OXFORDSHIRE COUNTY COUNCIL'S RESPONSE TO CONSULTATION ON THE FOLLOWING DEVELOPMENT PROPOSAL

Application no: 23/02715/REM

Proposal: Reserved matters approval for 23/01080/OUT - Details of access, appearance, landscaping, layout and scale relating to the proposed development of a Class E(g)(i) (formerly B1(a)) office/commercial building and associated development, plus associated car parking

Location: Land North Of Bicester Avenue Garden Centre, Oxford Road, Bicester

PROJECT BICESTER ARC - PLOT 1 - OFFICE BUILDING	
TITLE CYCLE STORE & BINS

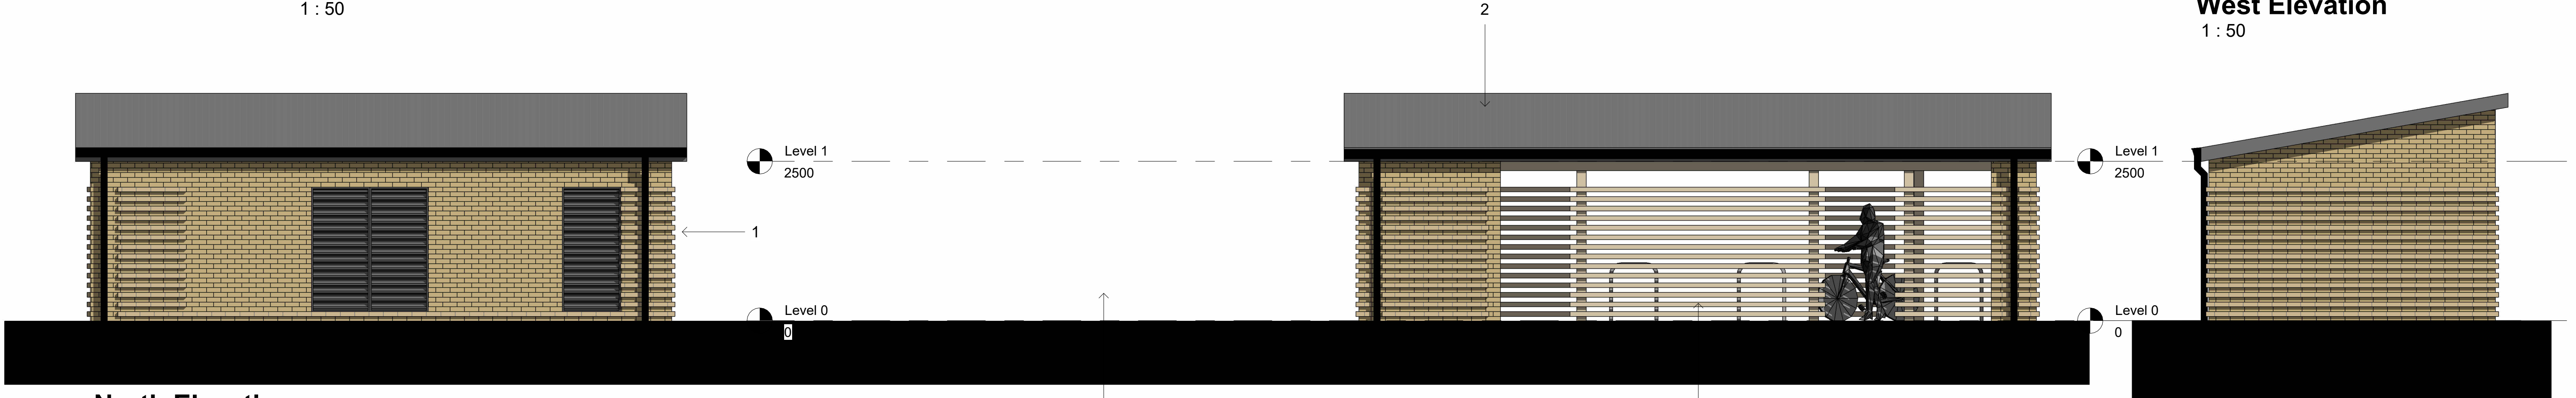
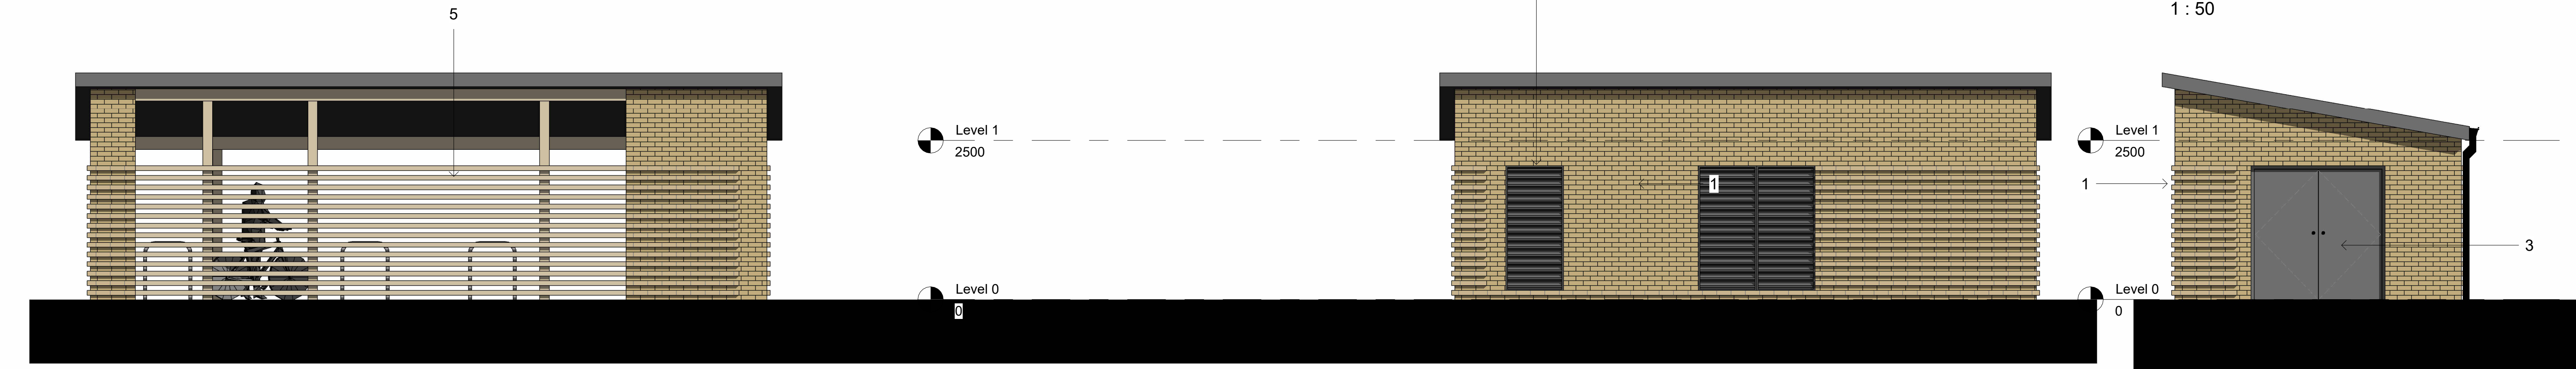
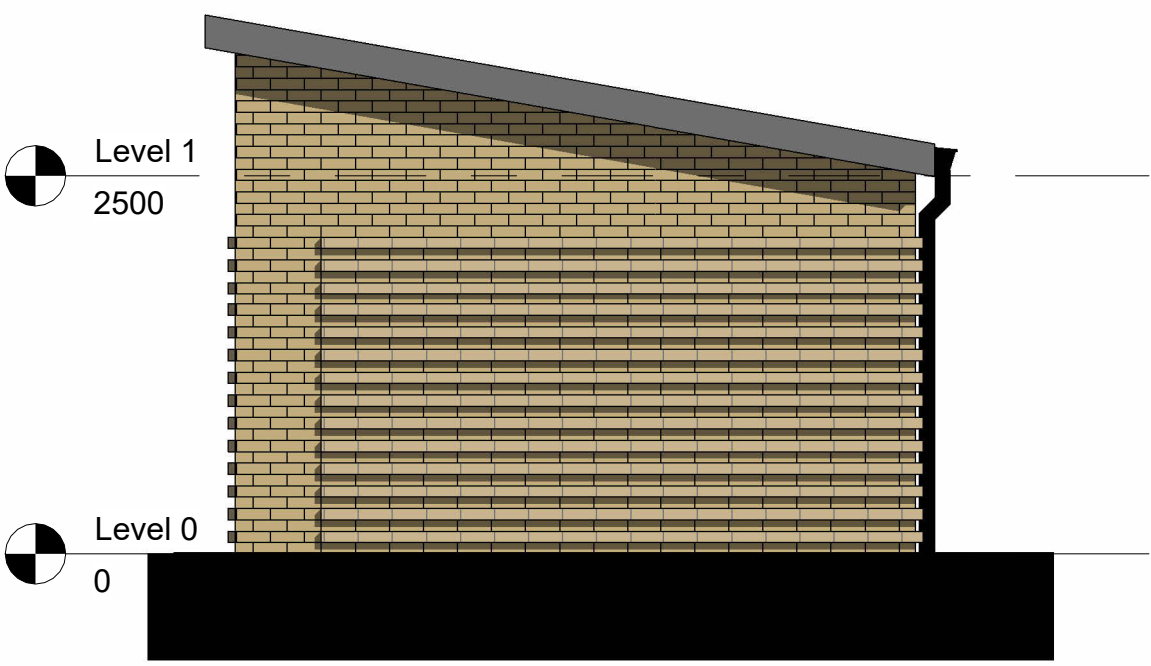
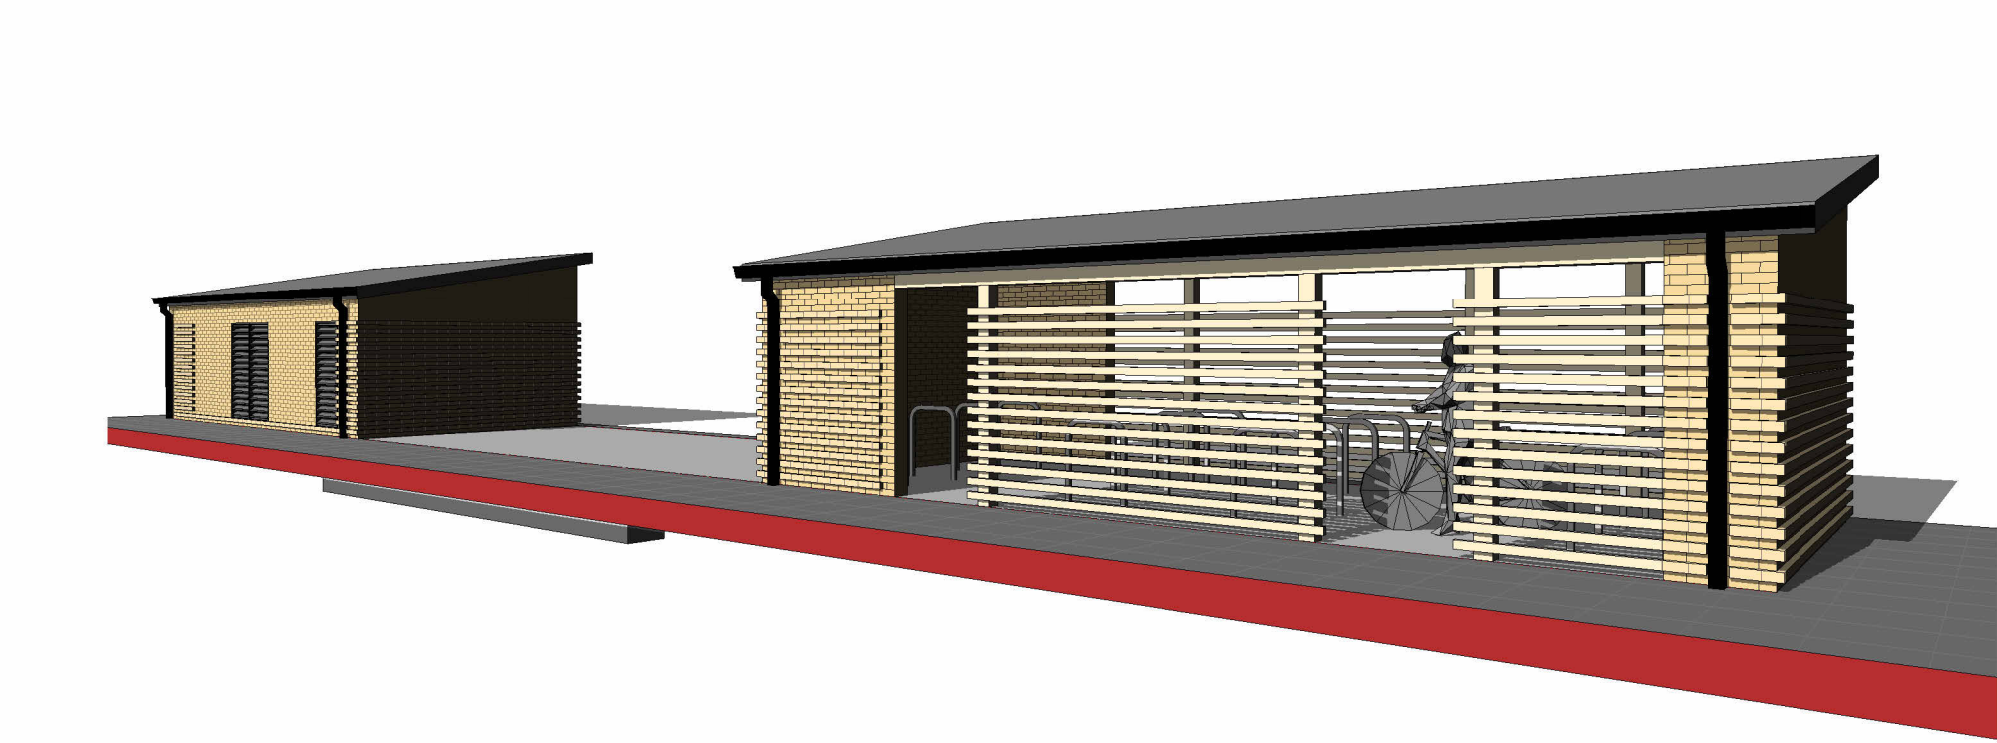
The proposed level of cycle parking is further noted to significantly fall short of the required. Again, set in the Parking Standards, the type and scale of this development requires up to 66 cycle parking spaces for staff and up to 26 for visitors. Visitor parking should ideally be covered and placed within proximity of the building entrances, while staff cycle parking must be in secure and sheltered facilities. See Table 5: Non-Residential Parking Guidance for Oxfordshire in OCC's Parking Standards. **(Reason to object)**
